ASSESSMENT REPORT

Student Accommodation Development 60-78 Regent Street, Redfern SSD 6724 MOD 3

LEVEL 01 PLAN

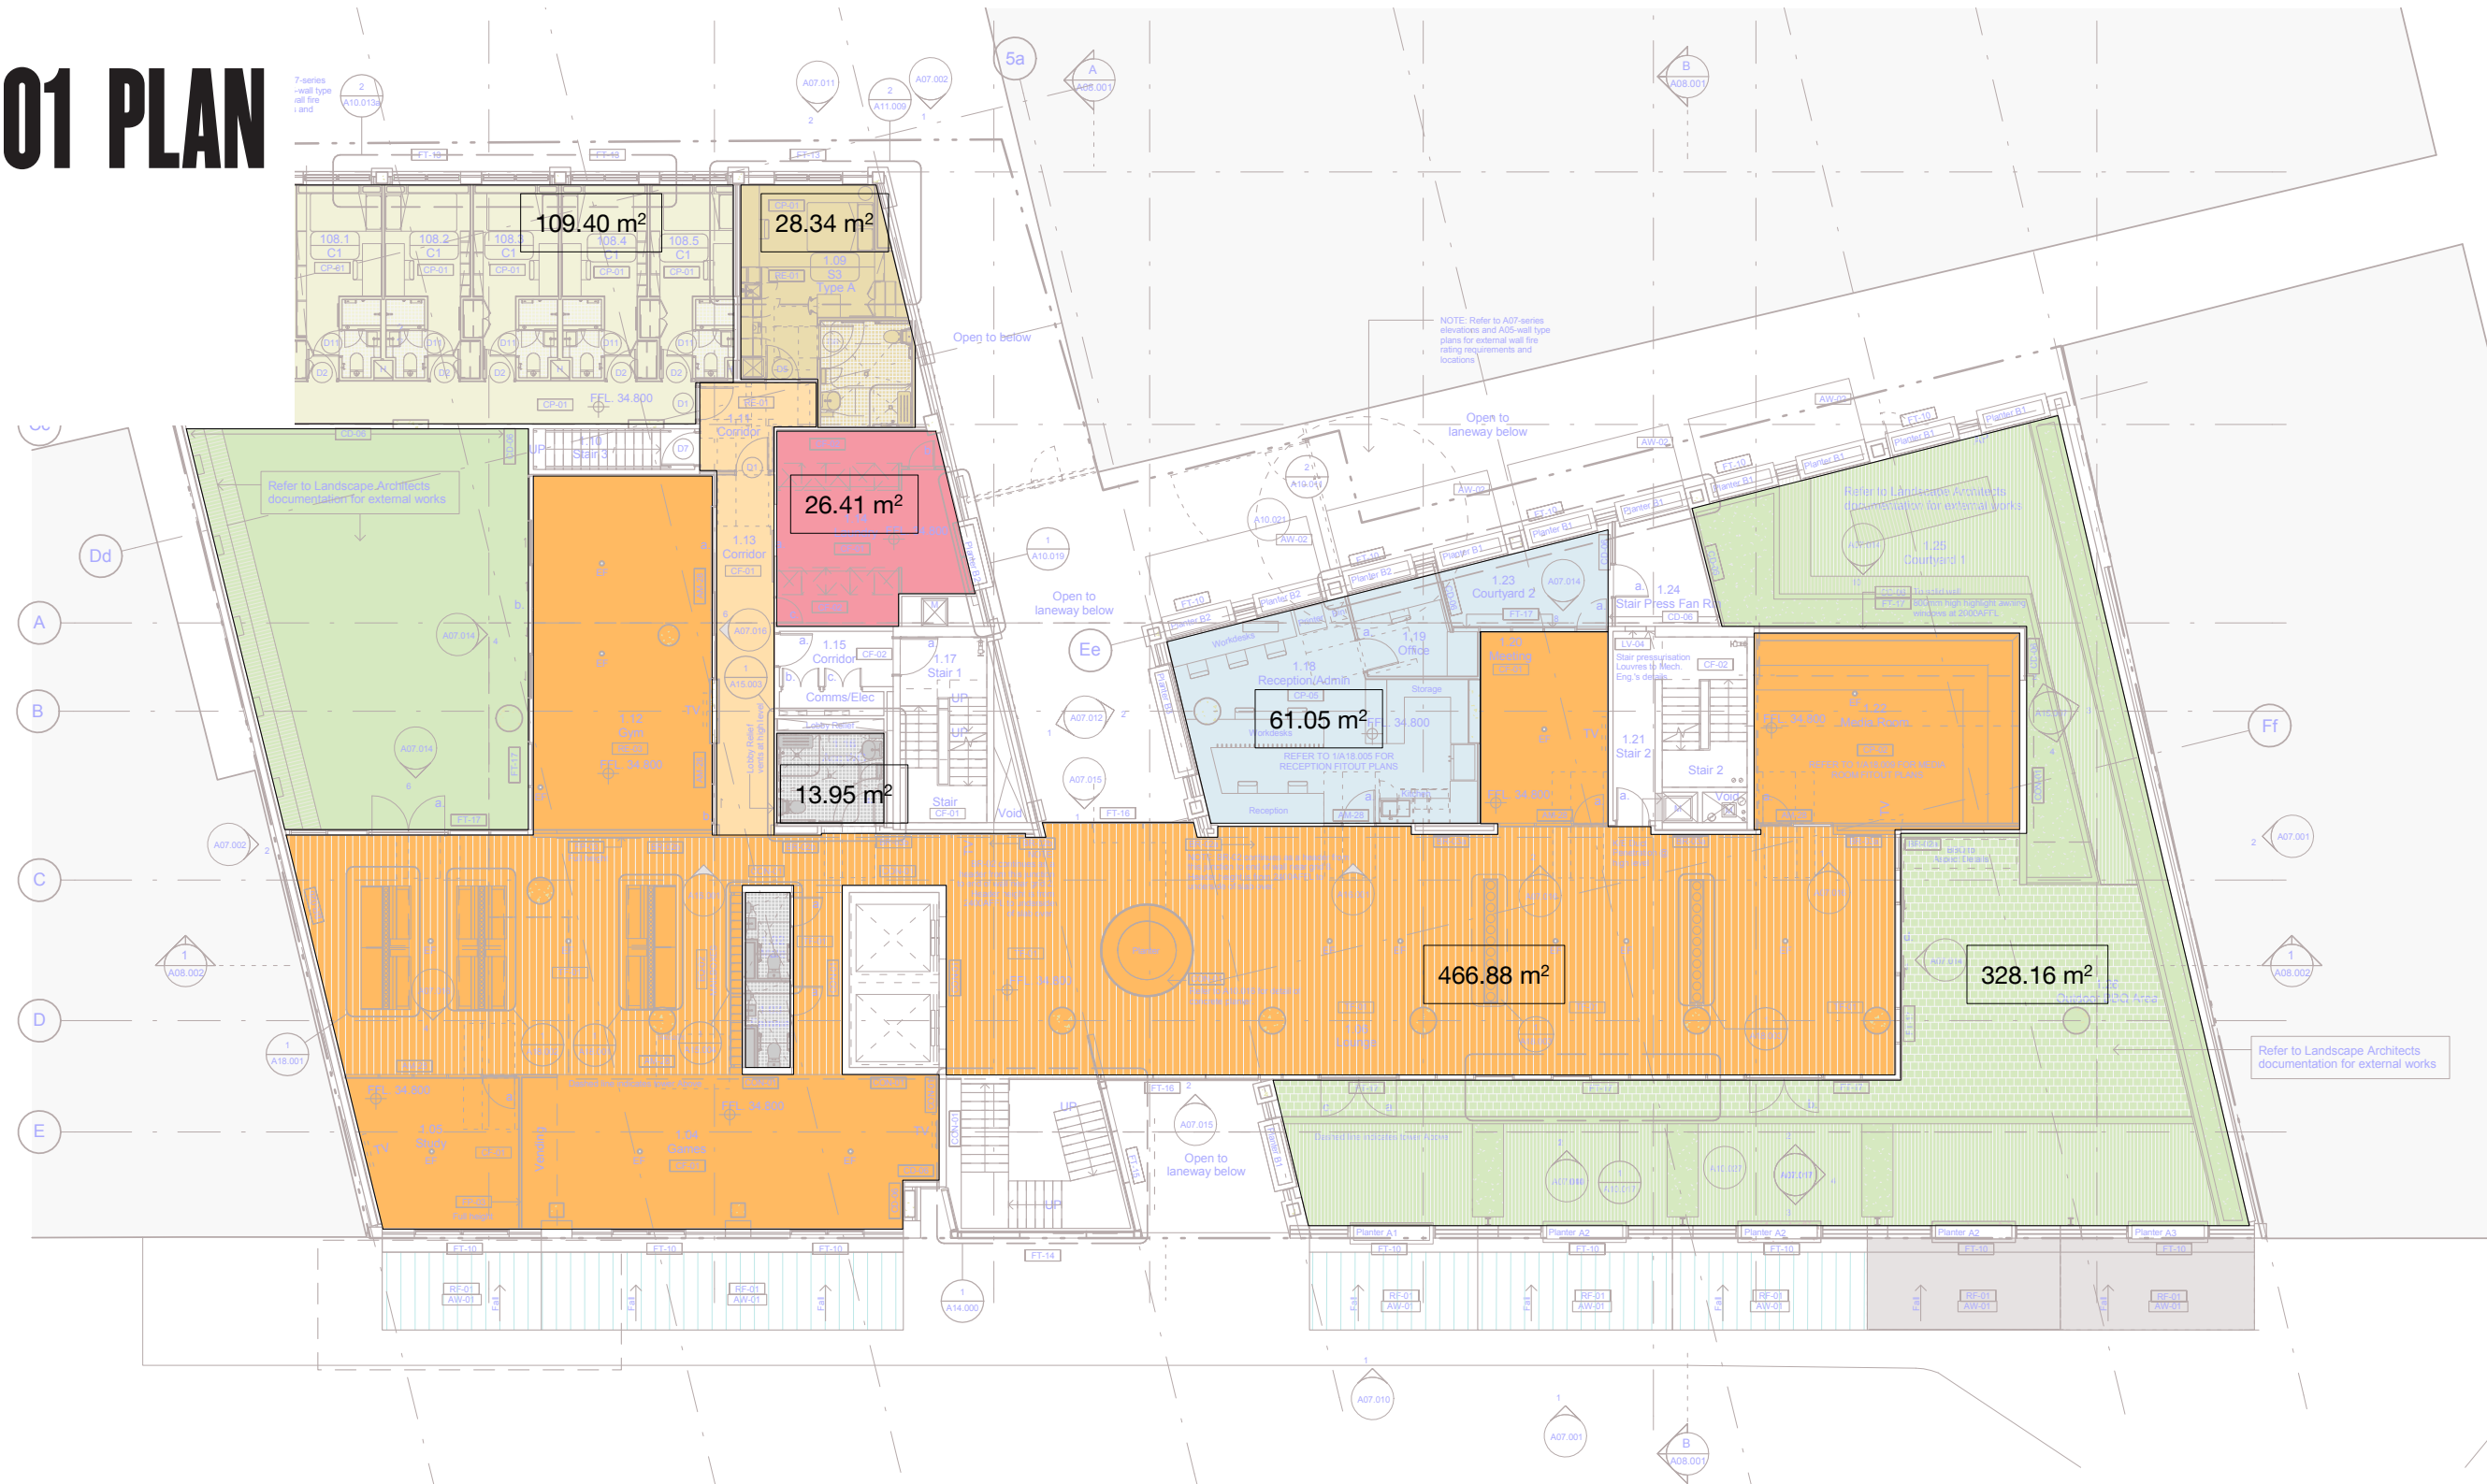
- the studio room sizes comply with the City of Sydney Development Control Plan 2012 (SDCP 2012) controls
- communal open space ought to be provided at a rate of 1.25m² per resident
- the laundry provisions should be increased to satisfy SDCP 2012 controls.

The RtS calculated that, on average, students are provided with 2.55m² of communal open space. The Applicant's calculation includes all Level 1 common areas and the communal open space within the cluster rooms located on Levels 02-17. The Department considers that due to the security card access requirements to enter the cluster rooms, they cannot reasonably be considered to provide communal indoor space for residents of the studio apartments. The Department calculates the communal indoor space available for the proposed additional studio occupants to be 1.03 m² which is 0.22m² less than the minimum communal indoor space area of 1.25 m² prescribed by SDCP 2012.

Notwithstanding this shortfall, the Department considers the proposed communal indoor space provided to the occupants of studio bedrooms is acceptable as:

- the proposed communal indoor space represents a minor non-compliance of 0.22m² (18%)
- the approved development includes 328m² of secure communal outdoor space. This is well in excess of the DCP minimum of 20m²
- the class attendance requirements associated with a typical student lifestyle results in occupants spending considerable time on campus where there is ample communal space for social interaction
- the central location of the development provides excellent access to shops, transport and other services, providing high levels of other sources of amenity.
